Application Ref:	3/2026/0224			 Ribble Valley Borough Council <small>www.ribblevalley.gov.uk</small>				
Date Inspected:	N/A	Site Notice:	N/A					
Officer:	AR							
DELEGATED ITEM FILE REPORT:					APPROVAL

Development Description:	Prior notification for proposed single storey rear extension under Part 1 Class A of the GDPO.		
Site Address/Location:	Old Rhodes Lords Lane Longridge PR3 2TA

PROPOSED ELEVATIONS

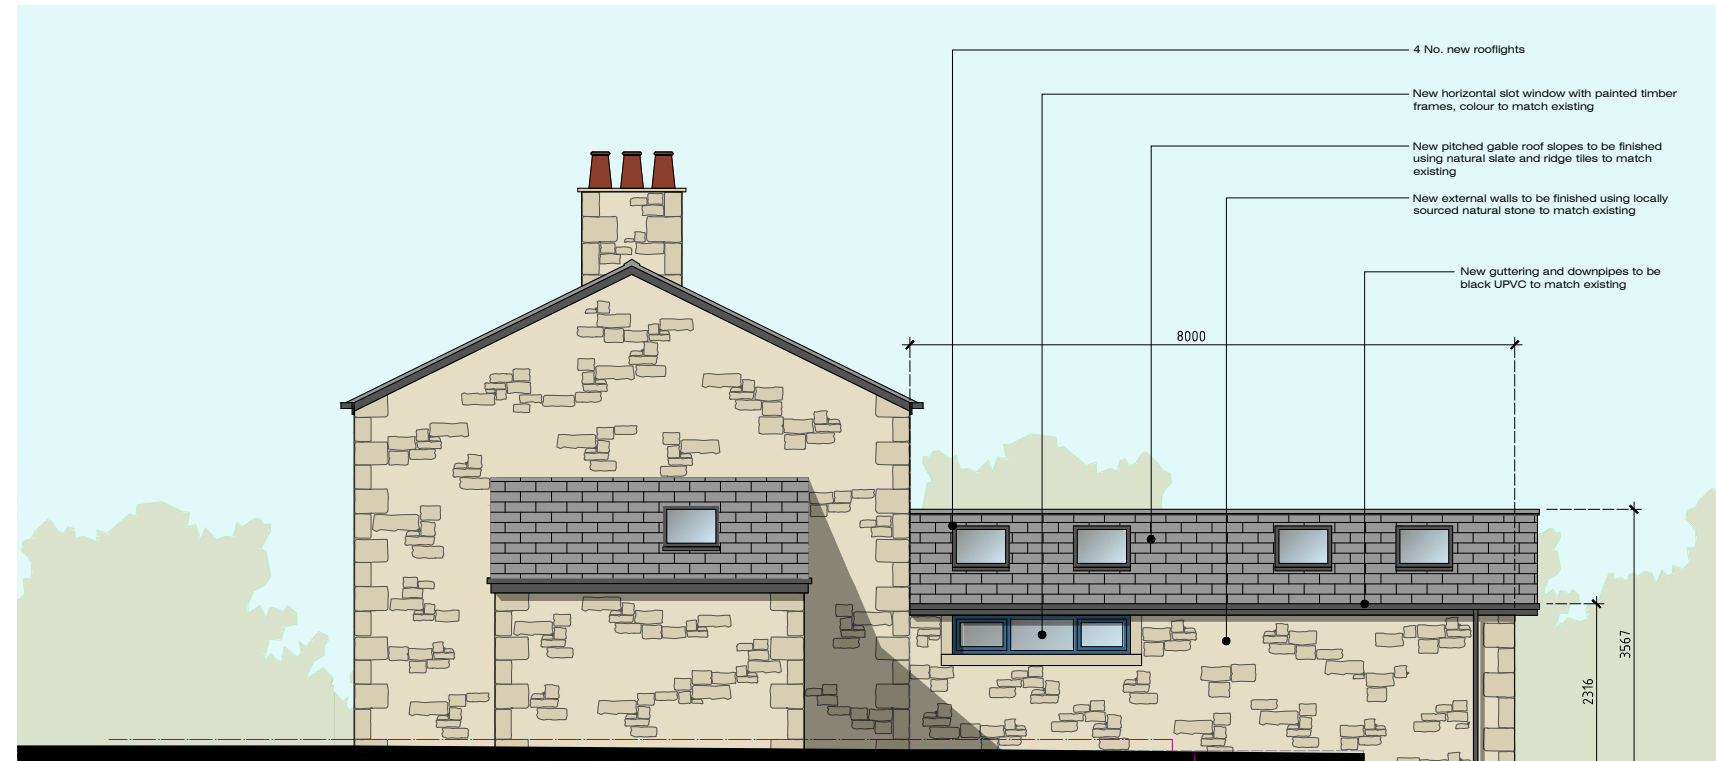
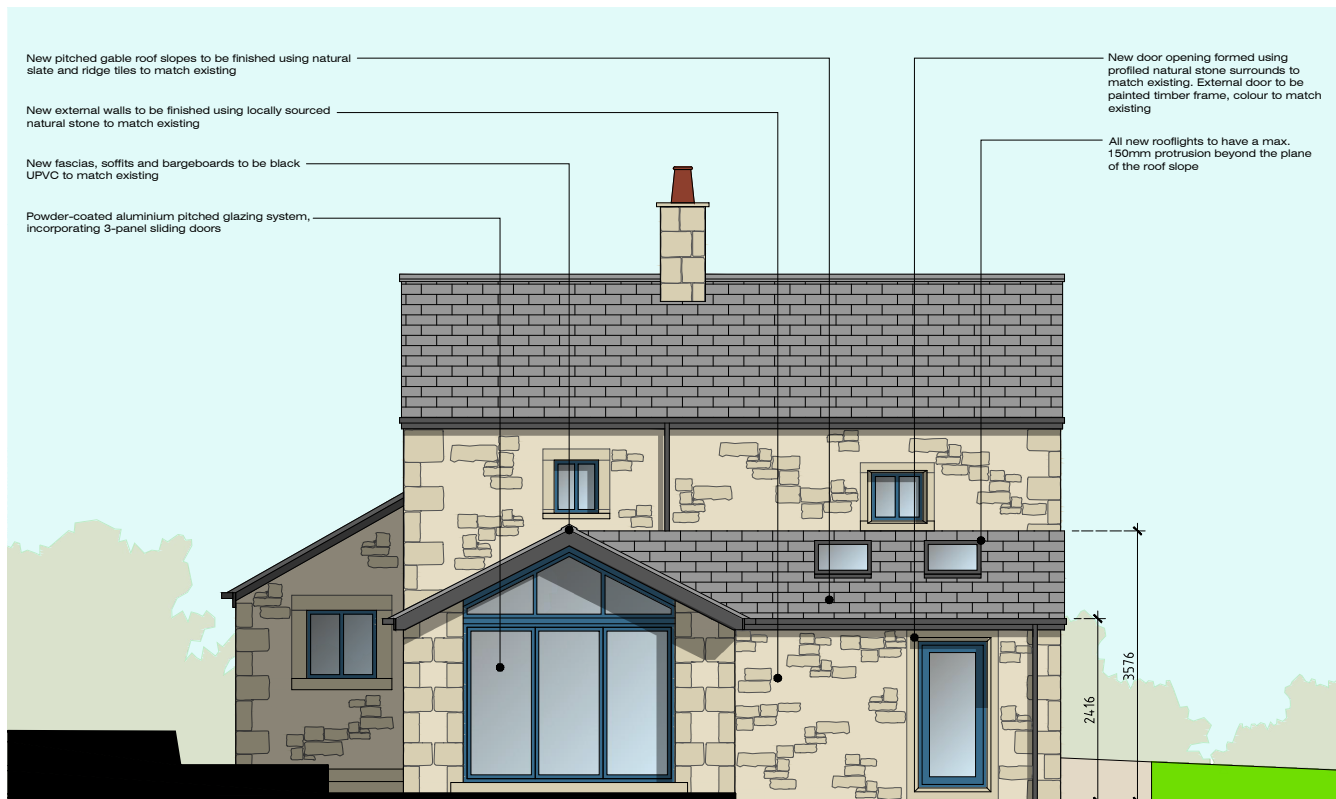
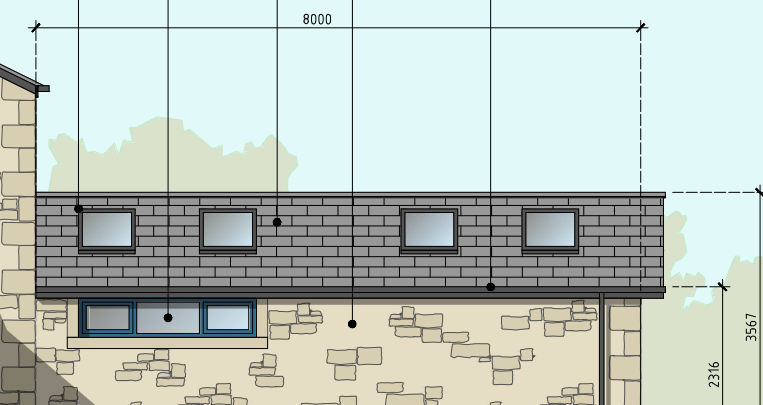
The proposed extension would be a single-storey structure adjoined to a detached dwellinghouse which would extend beyond the rear wall of the dwellinghouse by 8 metres and measure 3.56m at its highest point.

The dwellinghouse is not on Article 2(3) land nor on land of special scientific interest. The application property is a detached dwellinghouse, and the proposed extension would extend beyond the rear wall of the original property by 8m and would not exceed 4m in height. The proposal, therefore, complies with the above.

The proposed height of the eaves would exceed 3 metres; however, the enlarged part of the dwellinghouse would not be within 2 metres of the boundary of the curtilage of the dwellinghouse.

The proposed extension would be constructed in materials which would be of a similar appearance to those used in the construction of the existing dwellinghouse.

PROPOSED SITE & GROUND FLOOR PLAN

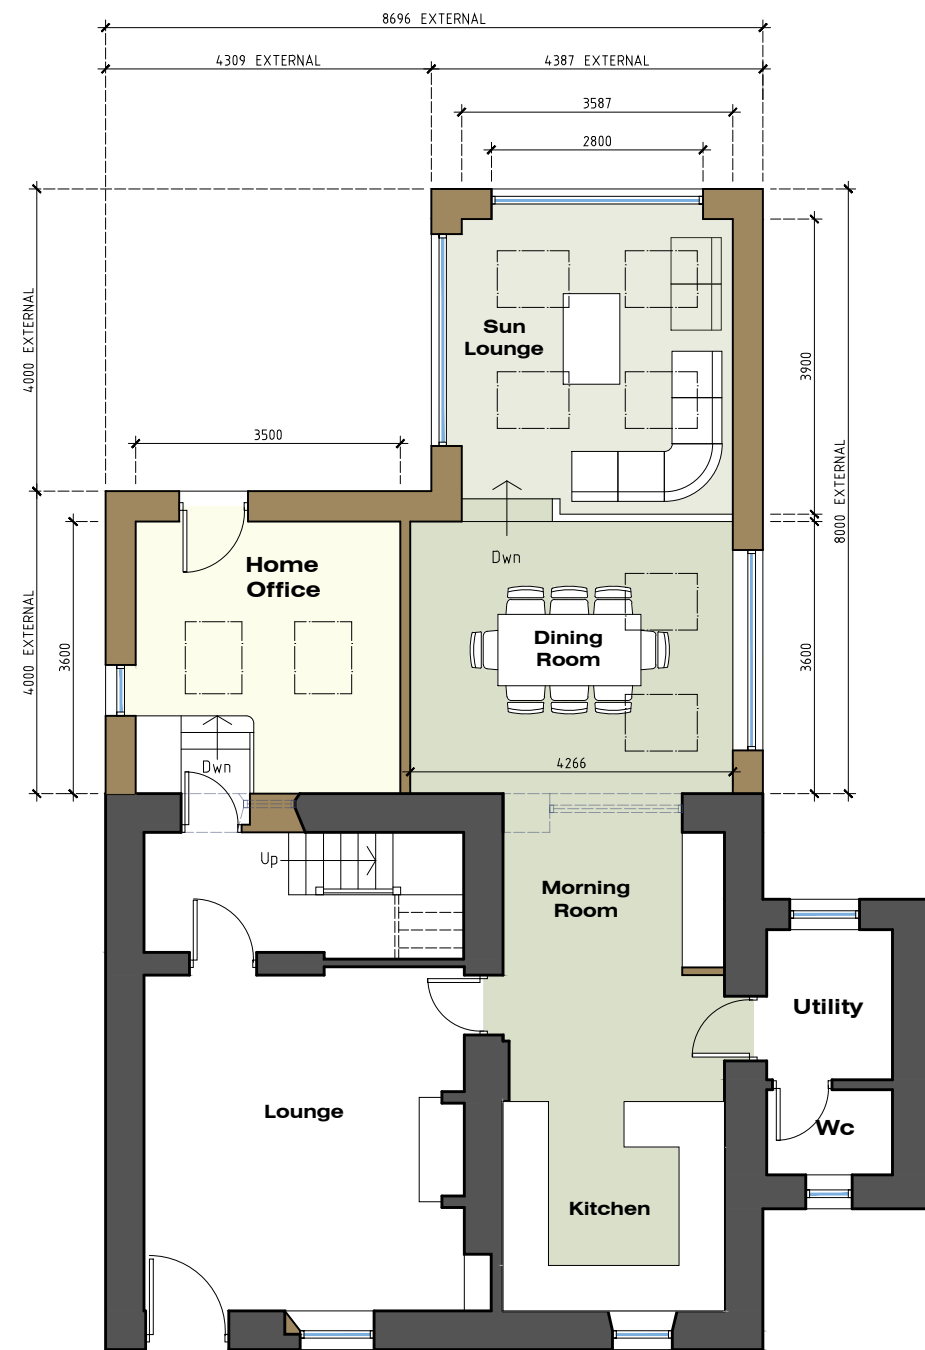
The extension would not exceed 50% of the total area of the curtilage of the dwellinghouse.

The proposed extension would not extend beyond a wall forming a side elevation of the original dwellinghouse.
